Bicester Gateway Phase 1b RMA

Response to OCC Comments on Application

Project: 226701

By: FC / Date: 22/09/22

STATUS: **INFORMATION ONLY**

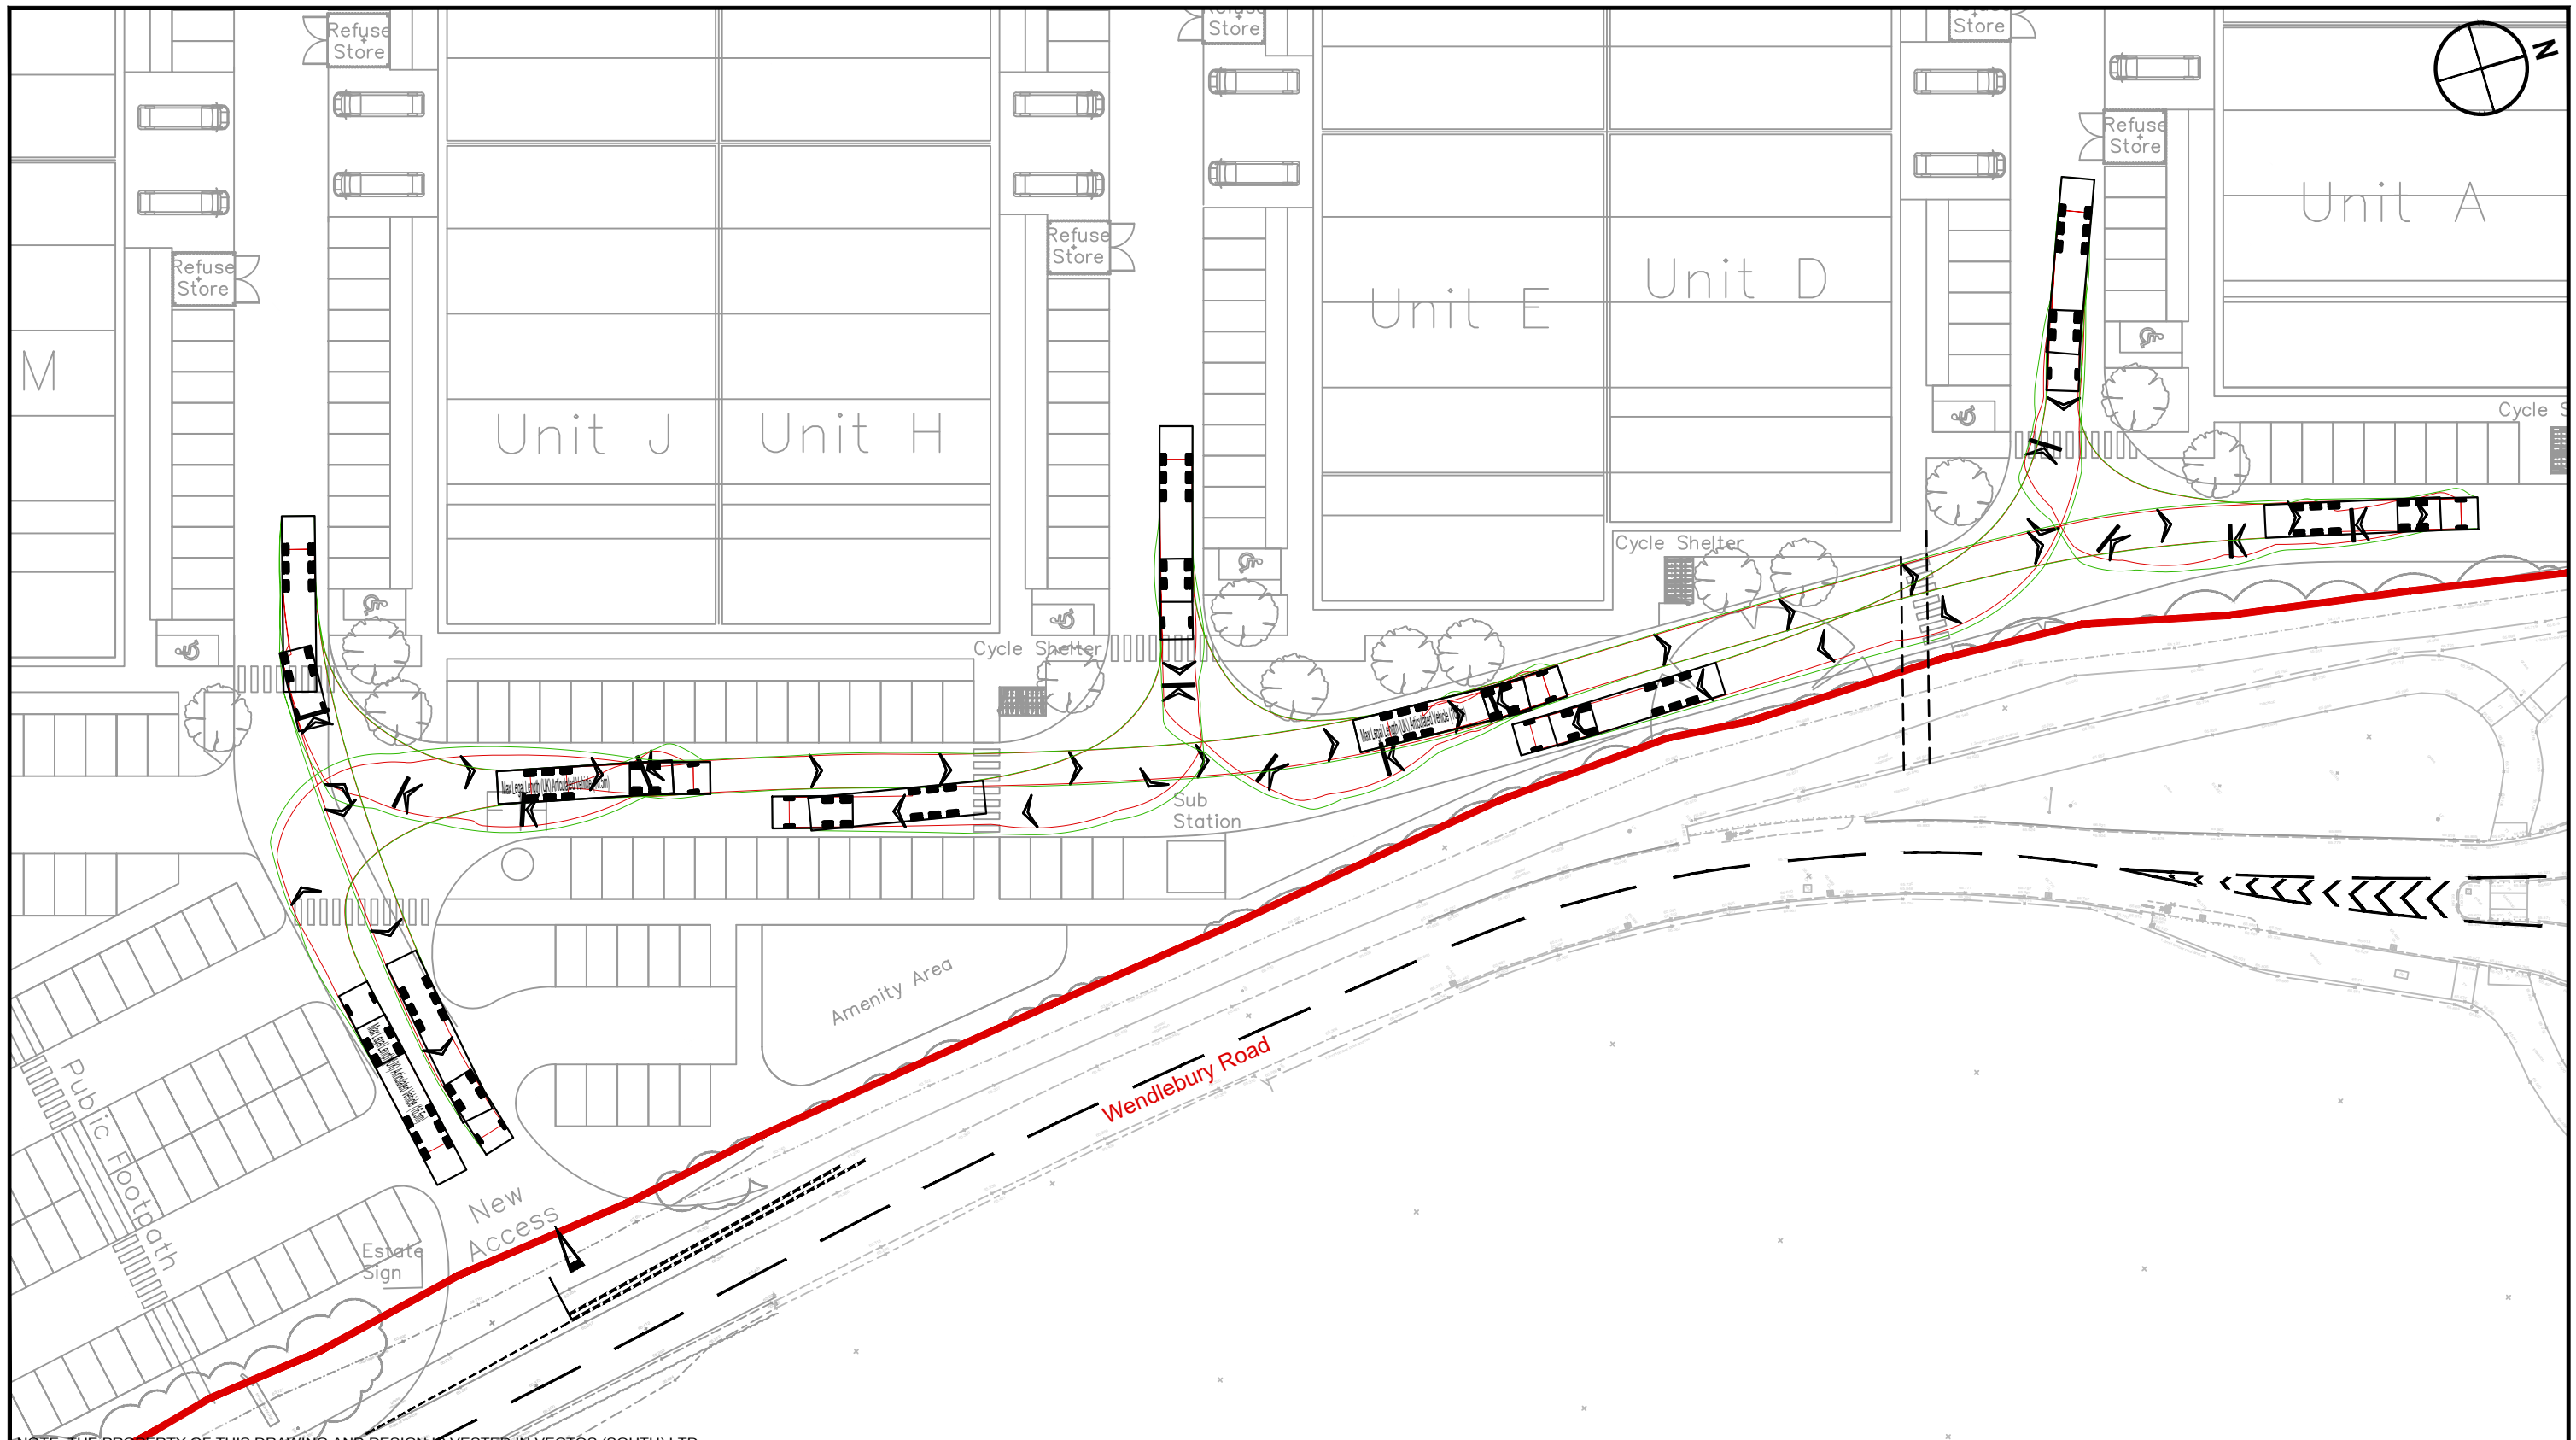
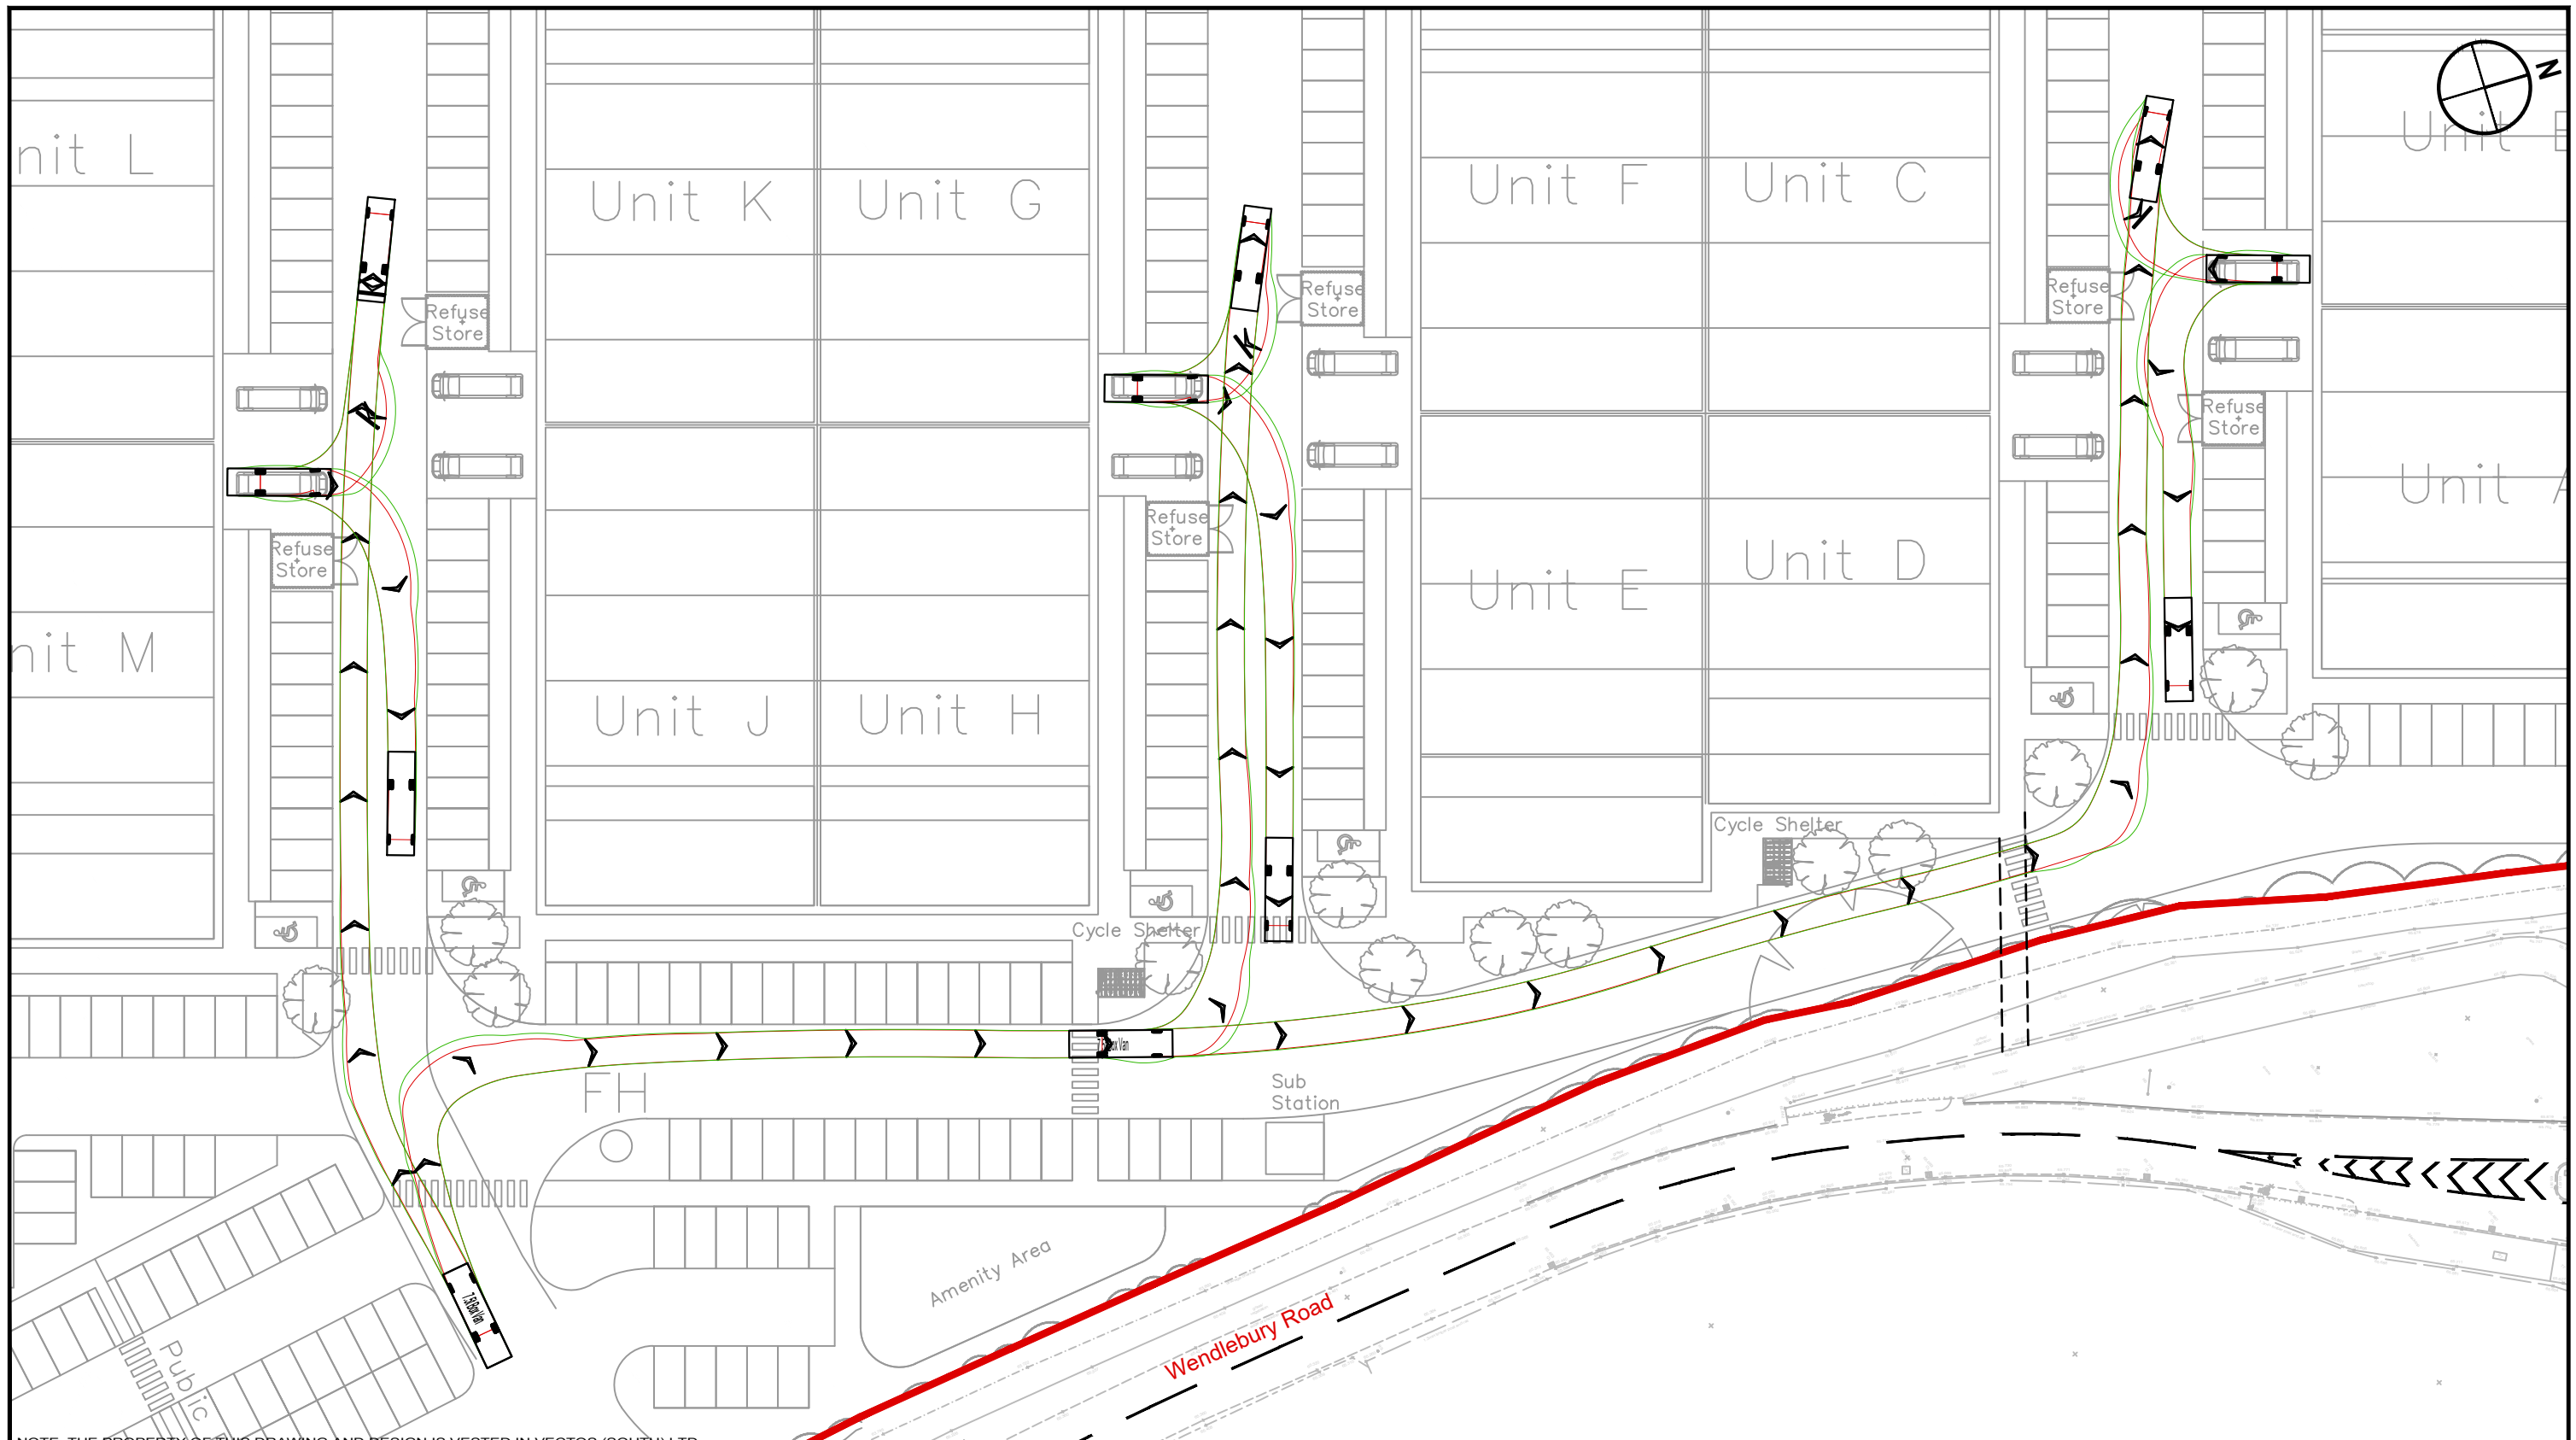
HGV tracking should be provided for entrance and exit of site. **Reason for objection.**

31. Drawings providing vehicle swept path analysis for a box van, a refuse vehicle, a 12m flat-bed lorry, and an articulated lorry are provided in the Transport Statement accompanying the Reserved Matters Application, in Appendix F. These drawings demonstrate that the proposed development can be accessed by a range of servicing vehicles to meet the requirements of prospective tenants on site. There is no need to provide this information again.
